From: Martin Hill <Martin.Hill@arun.gov.uk>
Sent: 12 November 2021 09:19
To: Planning.Responses <Planning.Responses@arun.gov.uk>
Subject: RE: Planning Consultation on: BN/142/21/PL

Comments from Private Sector Housing:

Application No: BN/142/21/PL
Registered: 9th November 2021
Site Address: 1 Como Barnham Road Eastergate PO20 3RT
Grid Reference: 494990 105301
Description of Works: Erection of a new two-storey building to contain 2 No 2 bedroom flats with associated parking, bin and bike stores and landscaping. This site is in CIL Zone 2 and is CIL Liable as new flats.

Ground Floor Plan

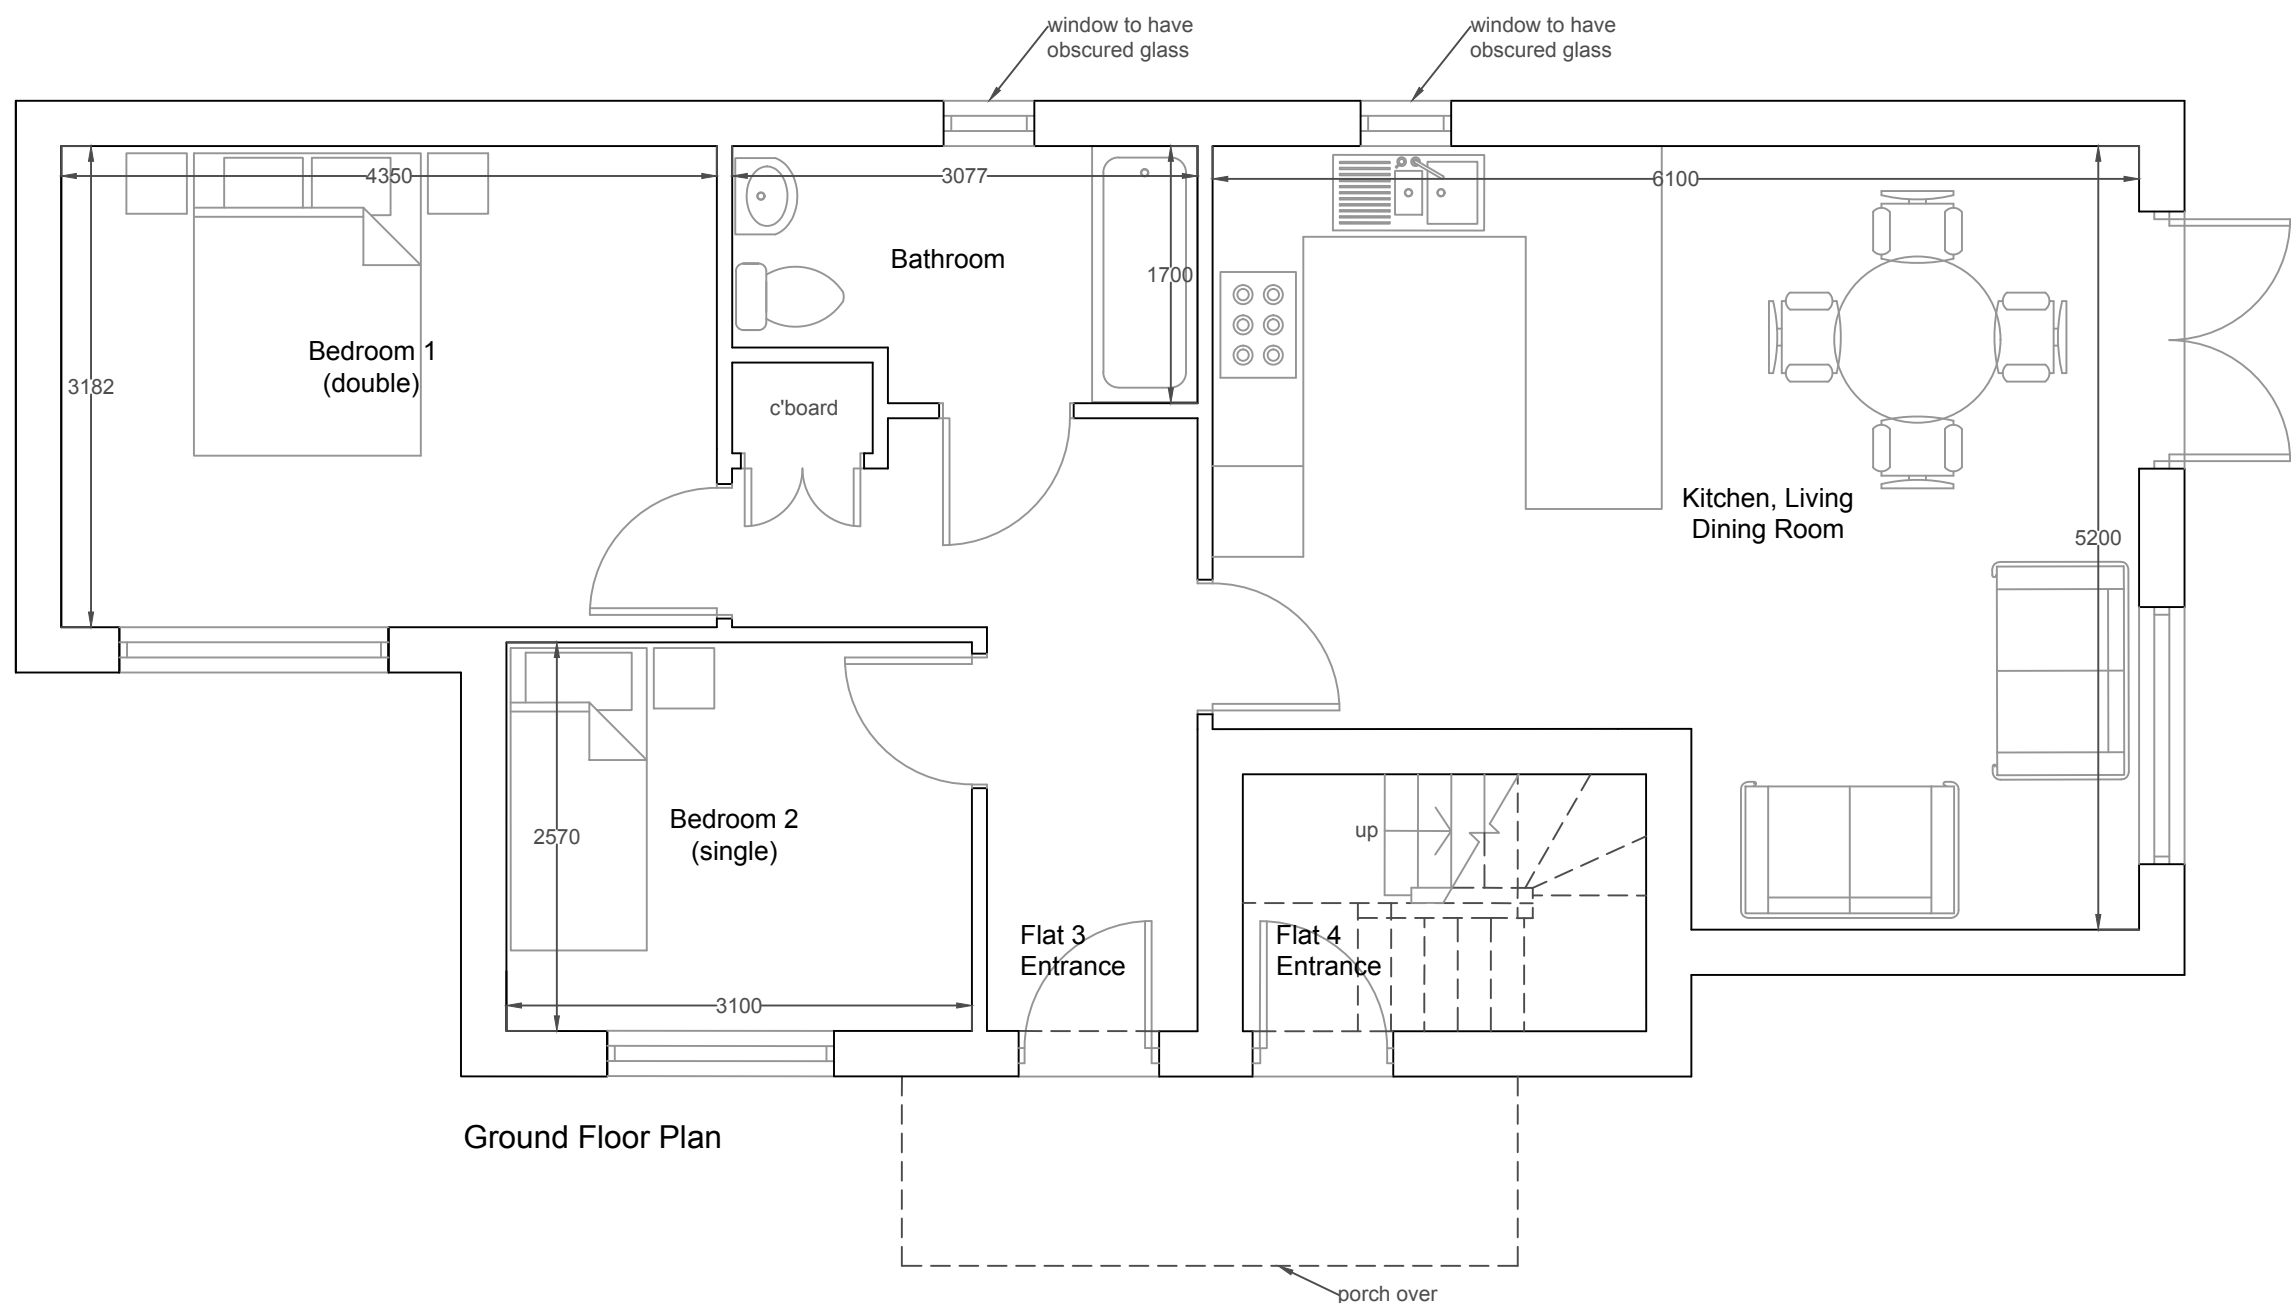
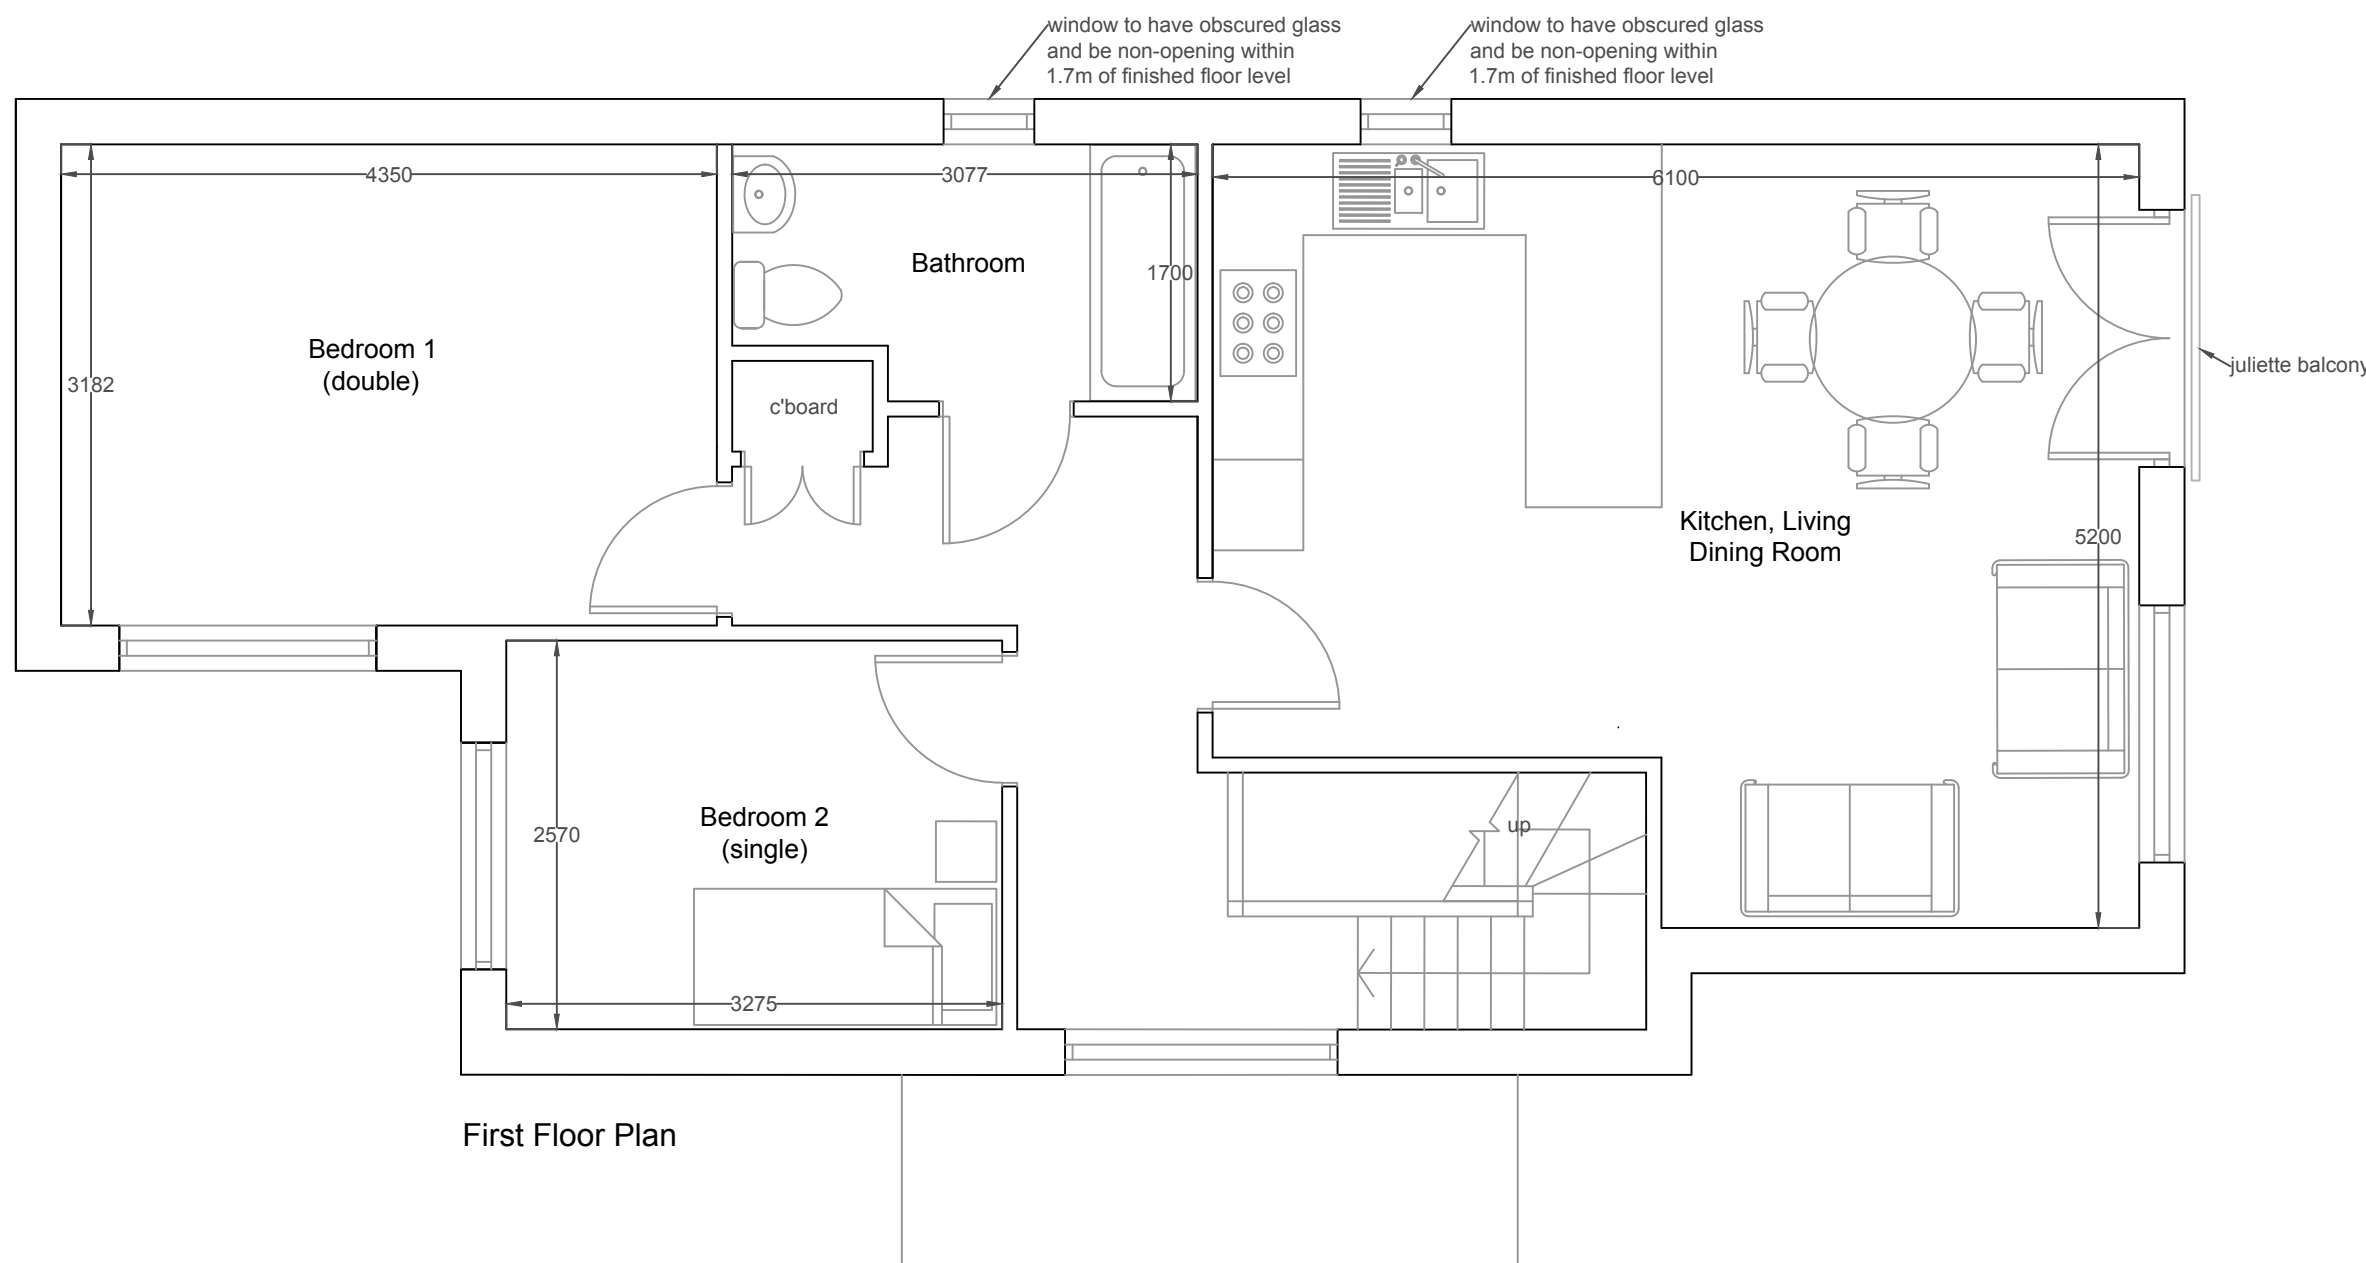
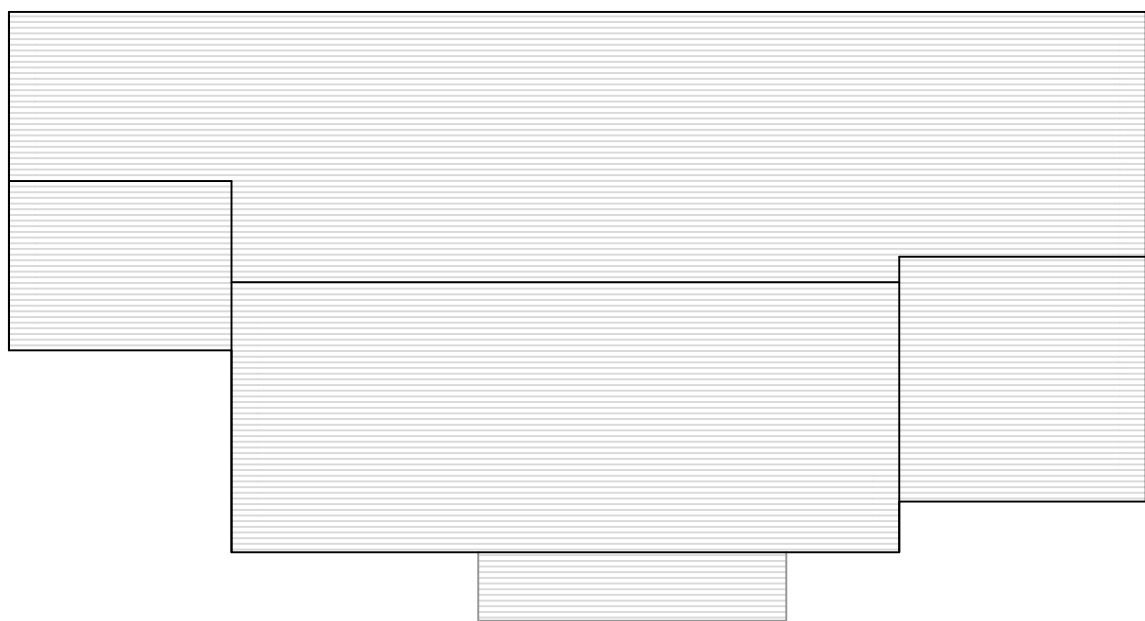
- Appropriate fire precaution facilities and equipment must be provided of such type, number and location as are considered necessary. Guidance on fire safety for this type of property can be found in the LGA guide "Fire Safety in Purpose Built Blocks of Flats" and in the approved suite of documents for Building Regulations.
- The Juliette balcony serving flat 4 appears to be situated in close proximity of the externally opening doors on the ground floor of flat 3, which presents an increased risk of fire spread from one compartment/dwelling to another. It is recommended that these two areas are separated sufficiently in order to prevent fire spreading between compartments externally or an alternative solution sought for the openings on the ground and first floors.

- There should be adequate horizontal and vertical fire separation, ensuring a minimum 60 minutes fire resistance is achieved between dwellings, including protection of the staircase serving flat 4.
- Grade D, LD3 fire alarm and detection system serving individual flats:
 - Interlinked smoke alarms with integral battery back-up located in the entrance hall of flat 3*.
 - Interlinked smoke alarms with integral battery back up located in the entrance hall of flat 4 at first floor level and an additional interlinked smoke alarm with integral battery back-up located at the ground floor entrance lobby level to flat 4.
 - *It is recommended to install interlinked heat alarms with integral battery back-up in each kitchen
